**From:** Myfanwy McNally <MMcNally@parracity.nsw.gov.au>  
**Sent:** Wednesday, 23 December 2015 4:05 PM  
**To:** Megan Fu  
**Subject:** FW: SSD 7262 Darcy Road Car Park and Associated Works  
**Attachments:** DarcyRdCumberlandRd.pdf

**From:** Richard Searle  
**Sent:** Tuesday, 22 December 2015 10:30 AM  
**To:** Myfanwy McNally  
**Subject:** SSD 7262 Darcy Road Car Park and Associated Works

DRAWING TITLE:
ROADWORKS
INSTITUTE ROAD
LONGITUDINAL SECTIONS
SHEET 1 OF 2

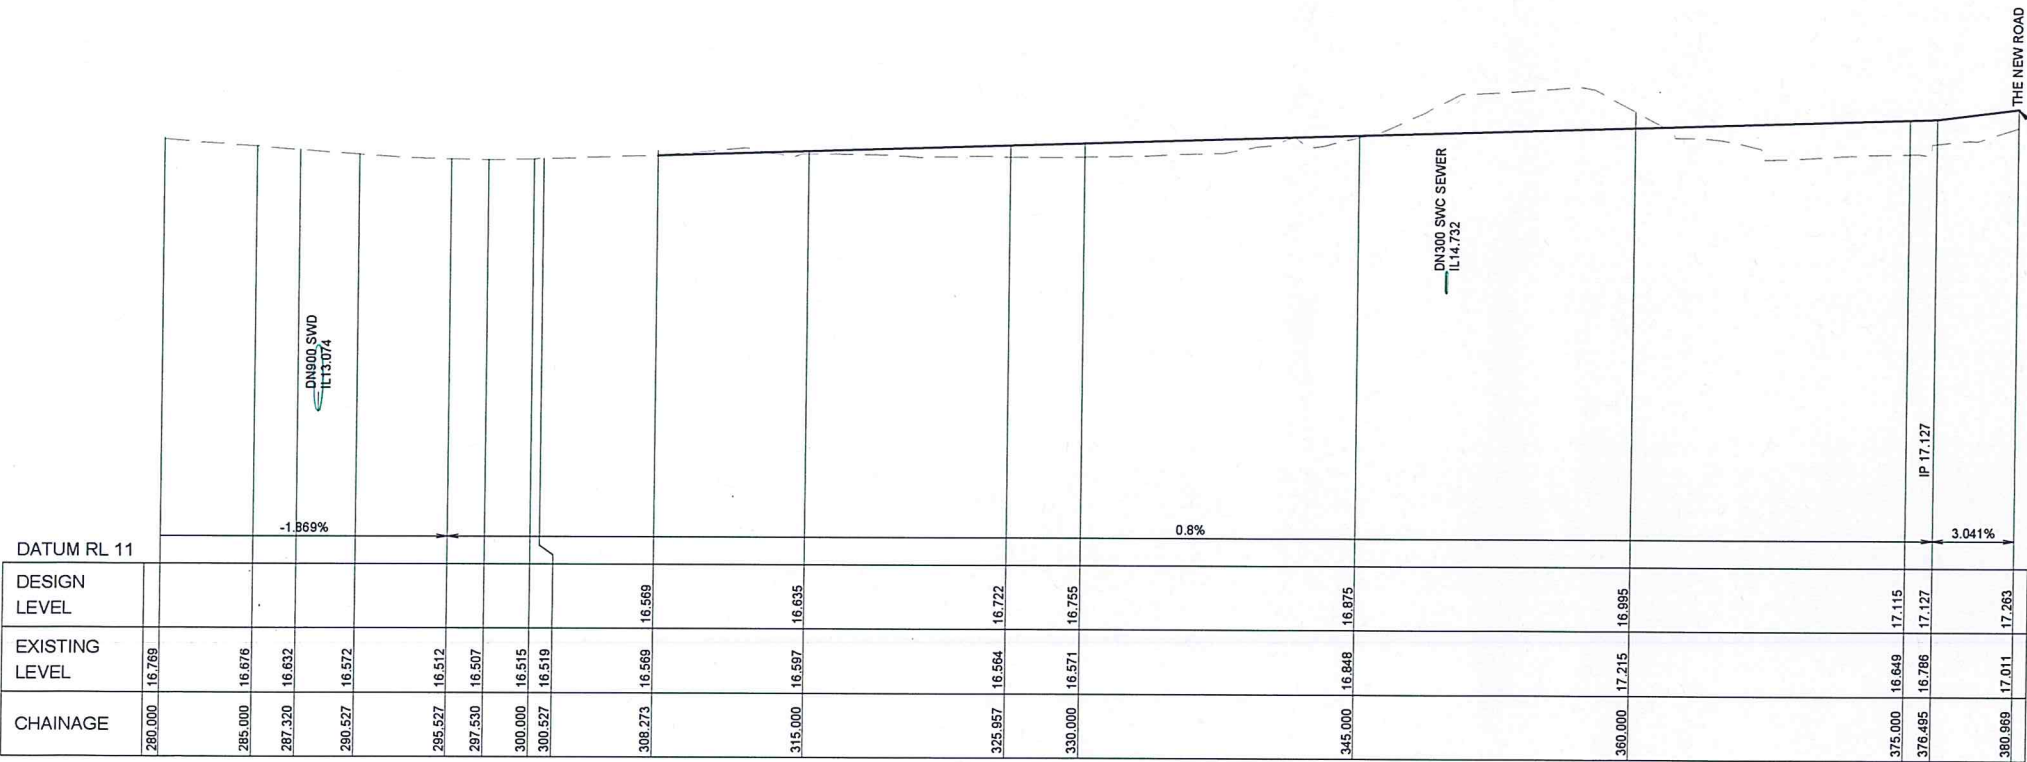
Institute Road, near Darcy Road is proposed to be narrowed, although maintaining its 2 lane westbound configuration. However, Institute Road could be widened to 3 lanes for approximately 40m on its westbound approach to Darcy Road with little effect on the landscaped area. This work is recommended. Note that the forecast increase in the afternoon peak westbound volume at this location is from 113 vehicles to 499 vehicles.
